MEMORANDUM

DATE: January 31, 2023

SUBJECT: SF-22-041 – Retreat at TimberRidge Filing No. 3
First Submittal

Engineering Division

80' R.O.W. TYPICAL RURAL MINOR COLLECTOR ROADWAY CROSS SECTION
SCALE: 1" = 10'

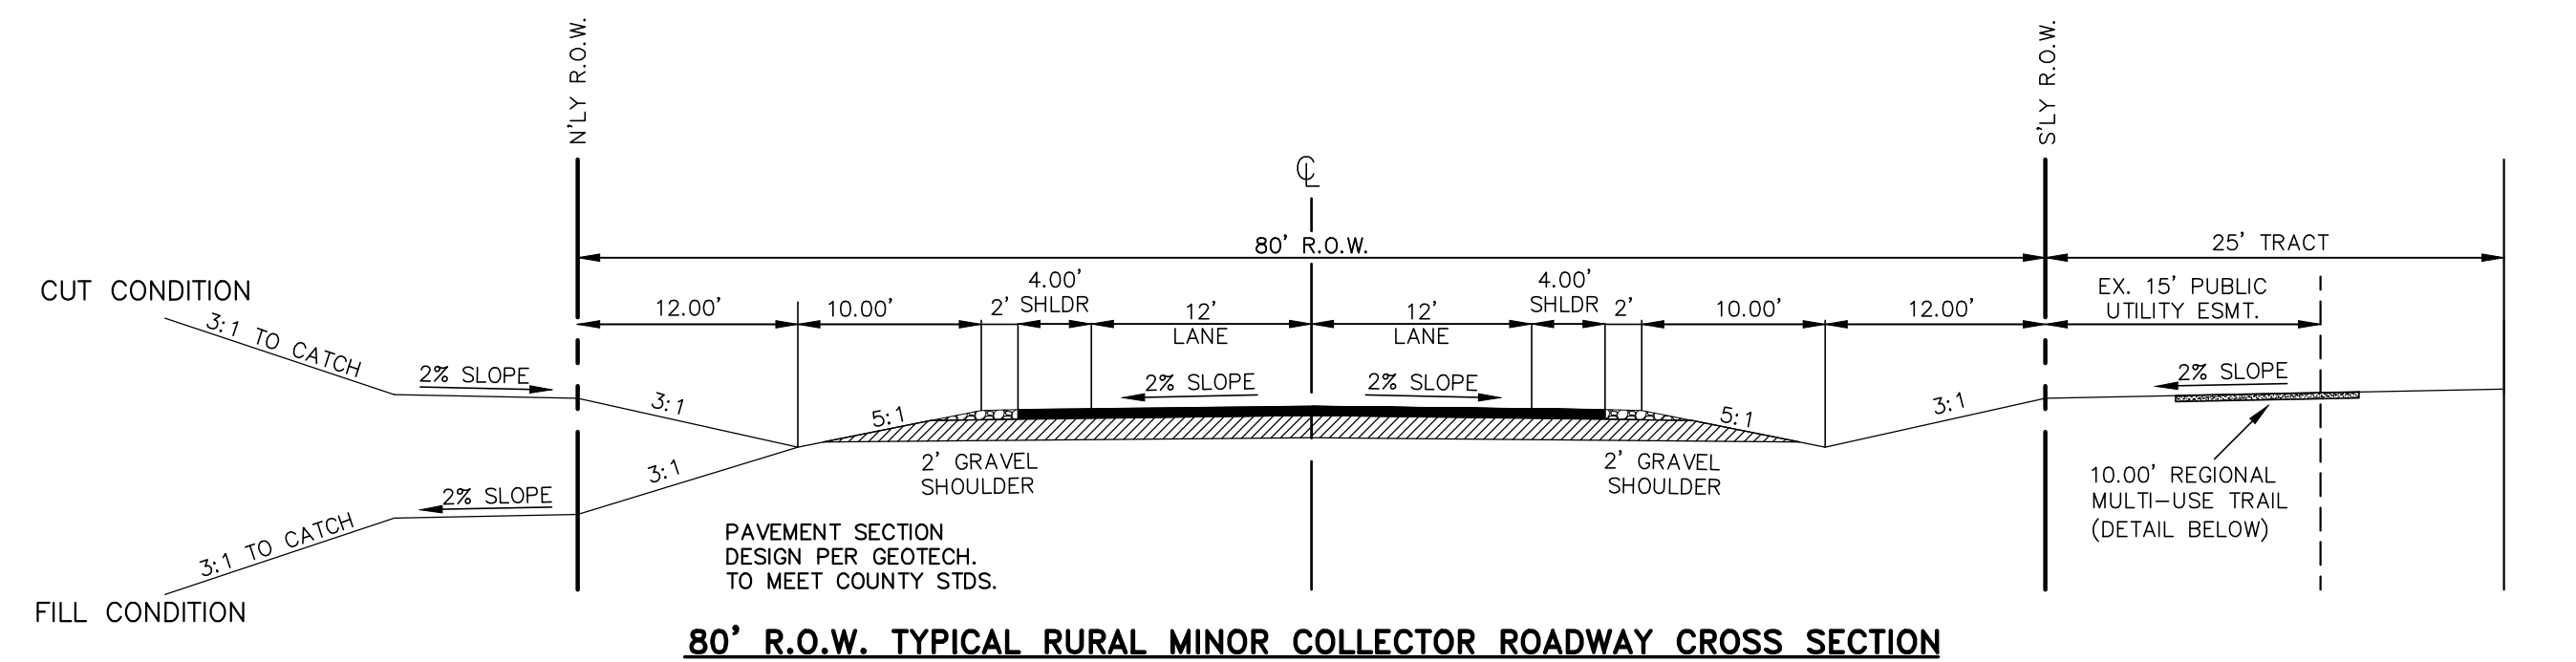
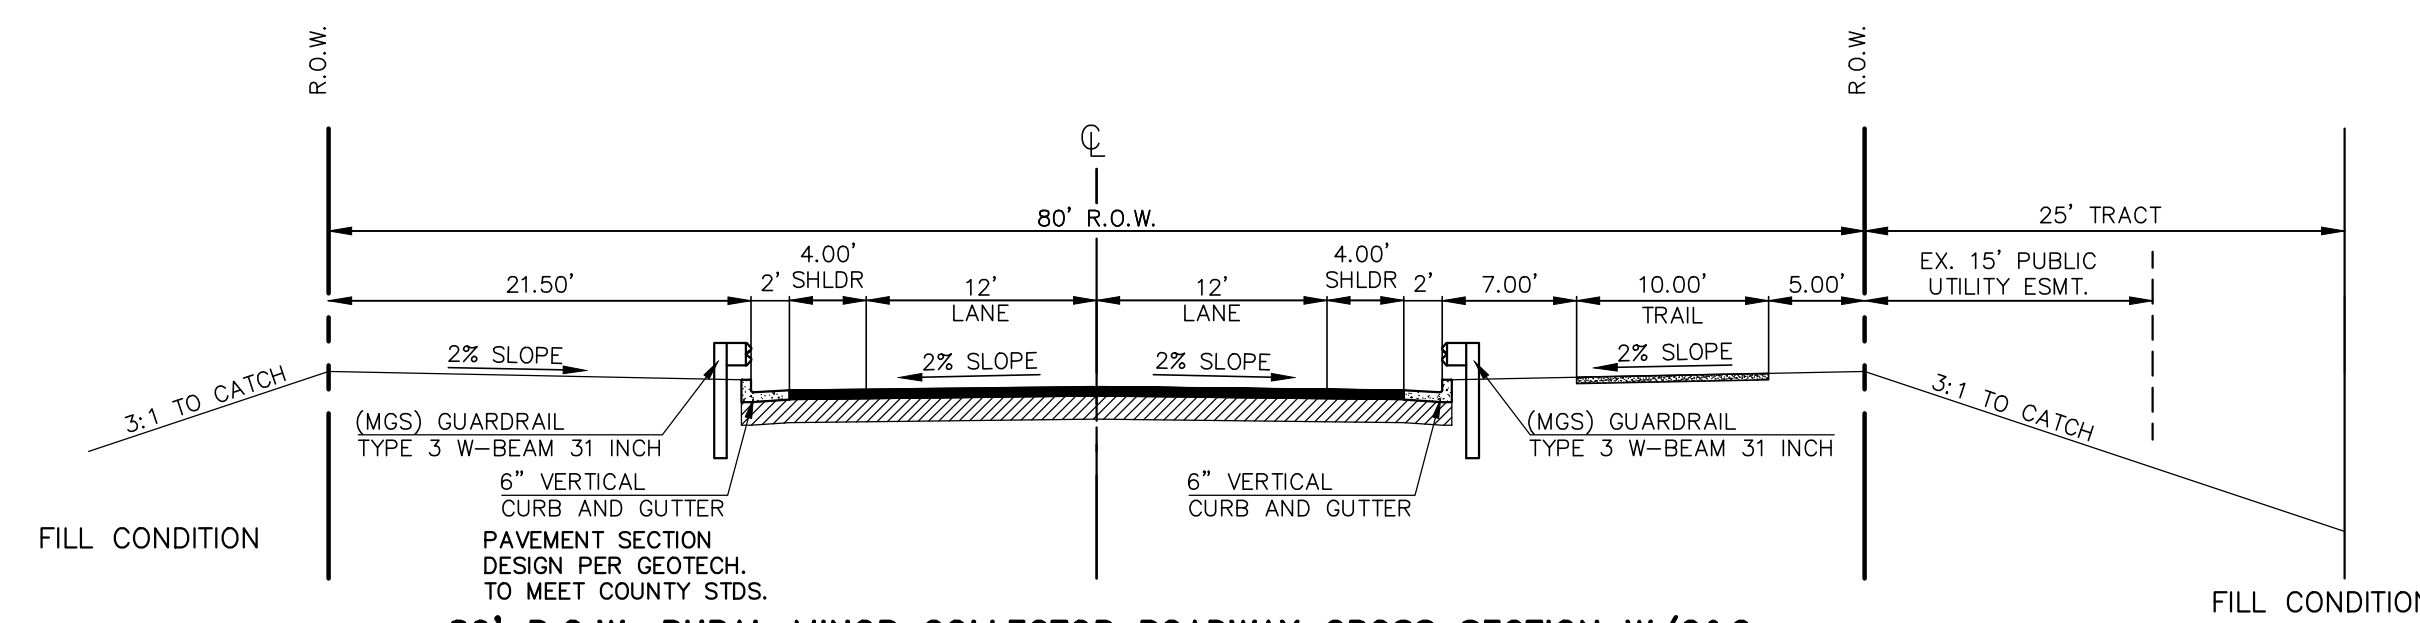
CDs show collector width construction

DESIGNED BY	PRA	SCALE	DATE	12-8-2022
DRAWN BY	ESO	(H) 1" = 50'	SHEET	5 OF 7
CHECKED BY	(V) 1" = 5'	JOB NO.	1185.30

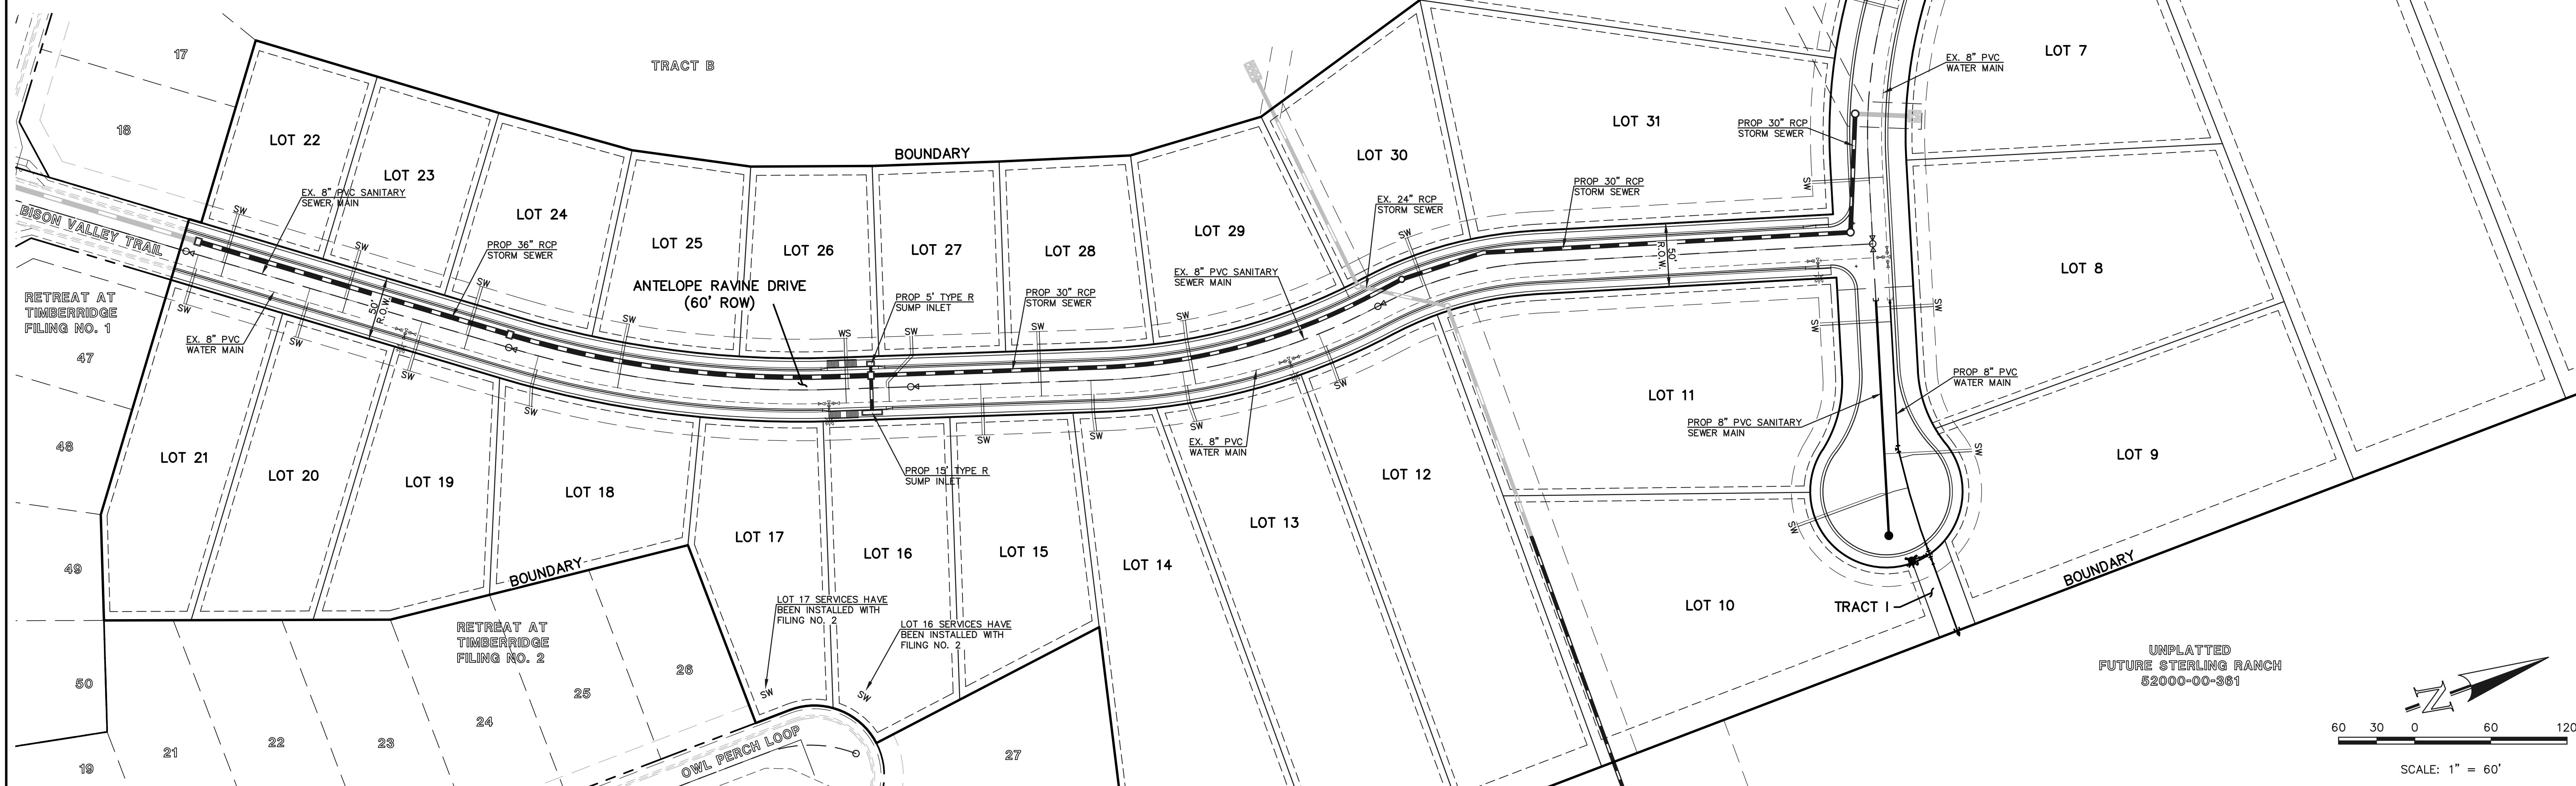
1. See CD/GEC redlines.
2. Provide the County CD signature block on the separate utility plans. Show the underdrain stub locations on the utility service locations details and note and/or show the underdrain system outfall(s) on the CDs. (Revise plat notes and provide a sump pump outlet plan for lots on urban roads if not proposed.)
3. Note: a pavement design report is required to be approved prior to base course installation.
4. Note: Bridge material design life certifications will be required prior to acceptance.
